RE: Harnett County Land Use Application 06-5-15961R

An Environmental Health Specialist from the Harnett County Health Department attempted to evaluate your property for the purpose of issuing an Improvement Permit. This individual was unable to evaluate your property for one or more of the following reasons.

Lot 43 Colonial Hills

- SITE PLAN FOR -  
 R & R ENTERPRISES OF FAYETTEVILLE, LLC  
 SUBDIVISION - COLONIAL HILLS SUBDIVISION  
 PHASE THREE MAP #2006-713  
 PIN 0506-13-9835.000

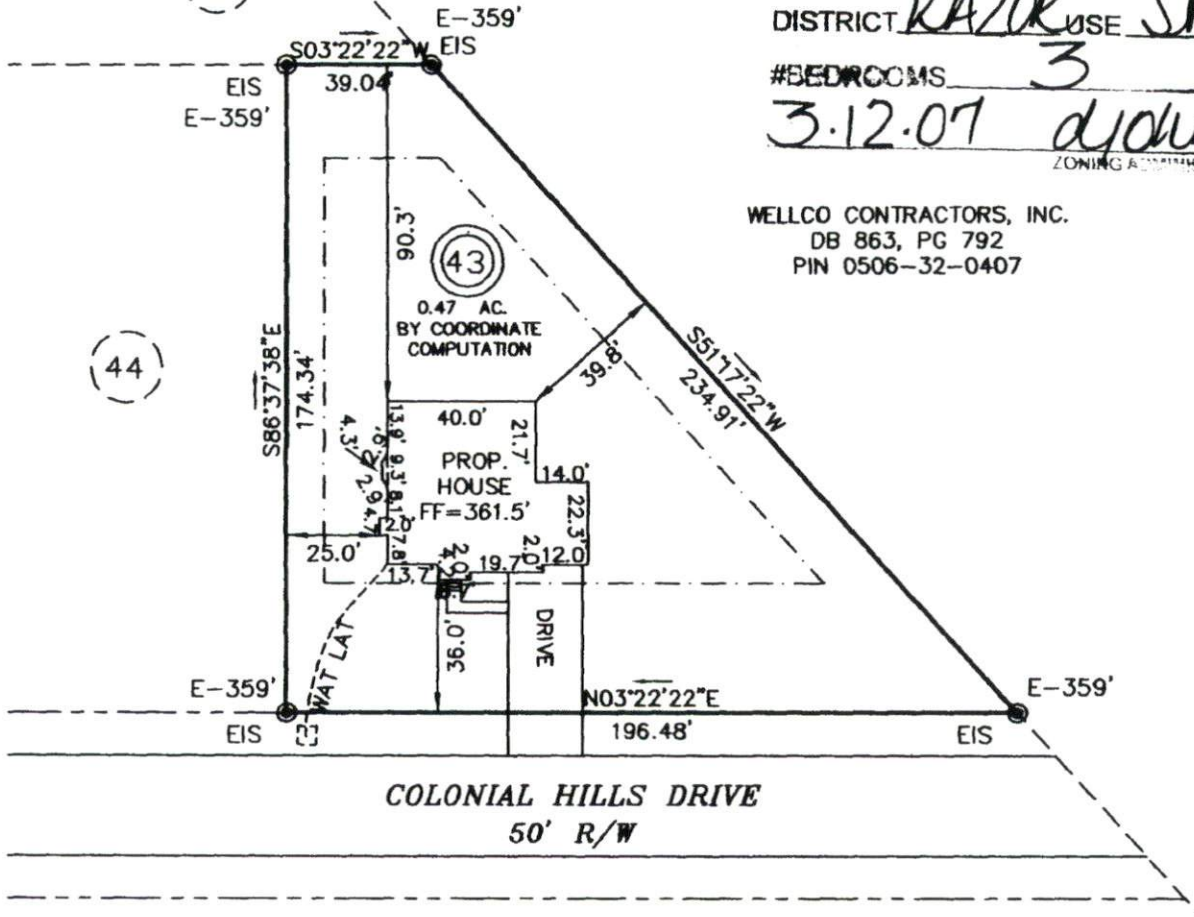
- 1. Property lines/corners not marked or labeled
- 2. House corners not marked or labeled
- 3. Directions not clear to property
- 4. Property needs brush or vegetation removed
- 5. Backhoe pits required
- 6. Other **Home must match attached plan. Please submit new plot plan with changes to Central Permitting and follow their instructions.**
